Inspector's Report ABP-316438-23

Whether the erection of tented structures within Thomond Park Stadium Grounds at Old Cratloe Road, Limerick for the sale of alcohol in association with match events, is or is not development and is or is not exempted development.

Thomond Park, Old Cratloe Road, Limerick

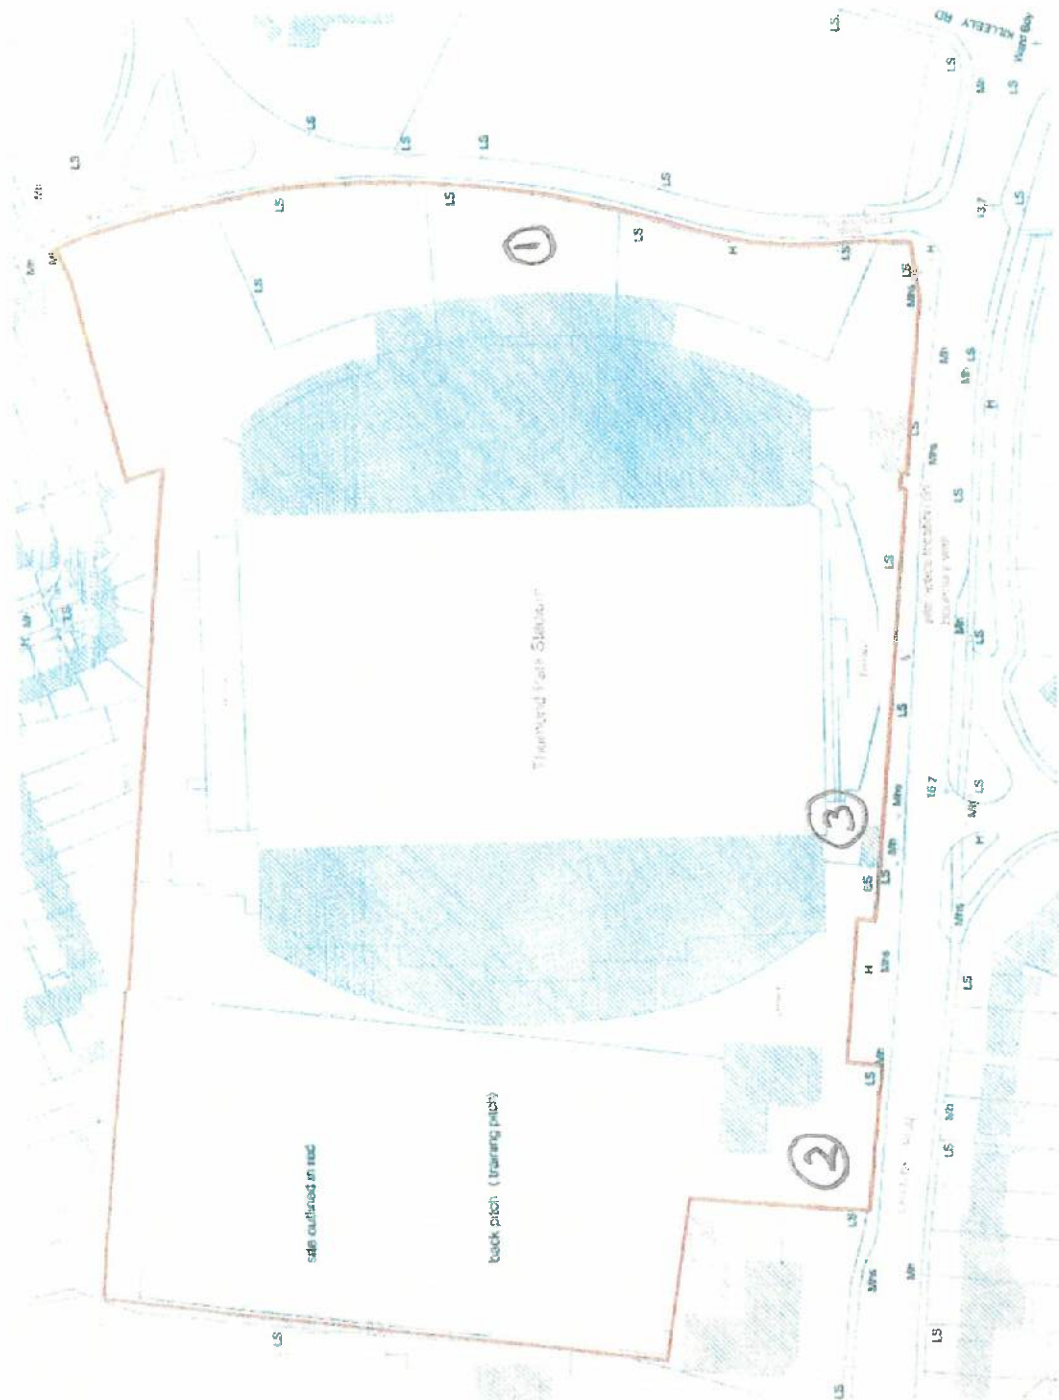
- No.1 on map: behind the Dug Out bar at eastern end of the stadium
- No. 2 on map: generally adjacent to Shannon RFC pavilion
- No. 3 on map: at the southern end of the grounds.

3.3. A map showing Location 1, 2 and 3 was lodged with the referral. The letter states tented structure (1) has been there almost permanently for the last number of years. Two images indicated as 'Google View' referenced as Location 1 were lodged with the Section 5. On site inspection, I noted that the large, tented structure shown on the 2no. 'Google View' images was not in place.

- 3.8. Given that tented structure (1) was not evident on site inspection, the matter of whether such a structure is development and if so, if it is exempt development, may be a moot point. In addition, I note that this structure is described by the planning authority as ‘an unauthorised structure’ subject of an enforcement case.

- 9.3.3. As the 3no. locations are (1) a hardsurfaced area to east of and external to Thomond Park stadium, (2) area south west of Shannon RFC clubhouse and (3) area west of south terrace of Thomond Park stadium, I consider that the use of such areas would be a material change of use and would therefore constitute 'development' as defined under section 3(1) of the Act.
- 9.3.4. The matter of compliance with *inter alia* Class 37 of the Regulations in the subject case is discussed in the following section.

- 9.4.7. Having regard to the size and capacity of this stadium, I do not consider that match events at this stadium would come within the meaning of 'local event'. Notwithstanding therefore that the match events may be considered to be of 'sporting character', given that such events are not 'local', I do not consider that the tented structures and the use thereof would fall within the scope of Class 37. Accordingly, I consider that the 3no. tented structures subject of this referral constitute development and do not constitute exempt development.

- (a) The erection of 3no. tented structures within Thomond Park Stadium grounds, Old Cratloe Road, Limerick, as shown on the attached map and marked location 1, 2 and 3, for the sale of alcohol in association with match events, is works, and therefore constitutes development
- (b) Such works do not fall within the scope of the exemption set out at Class 37 of Part 1, Schedule 2 of the Planning and Development Regulations 2001, as amended, as the match events are not considered to be 'local'

NOW THEREFORE An Bord Pleanála, in exercise of the powers conferred on it by section 5(3)(a) of the 2000 Act, hereby decides that the erection of 3no. tented structures within Thomond Park Stadium grounds, Old Cratloe Road, Limerick, as shown on the attached map and marked location 1, 2 and 3, for the sale of alcohol in association with match events is development and is not exempted development.
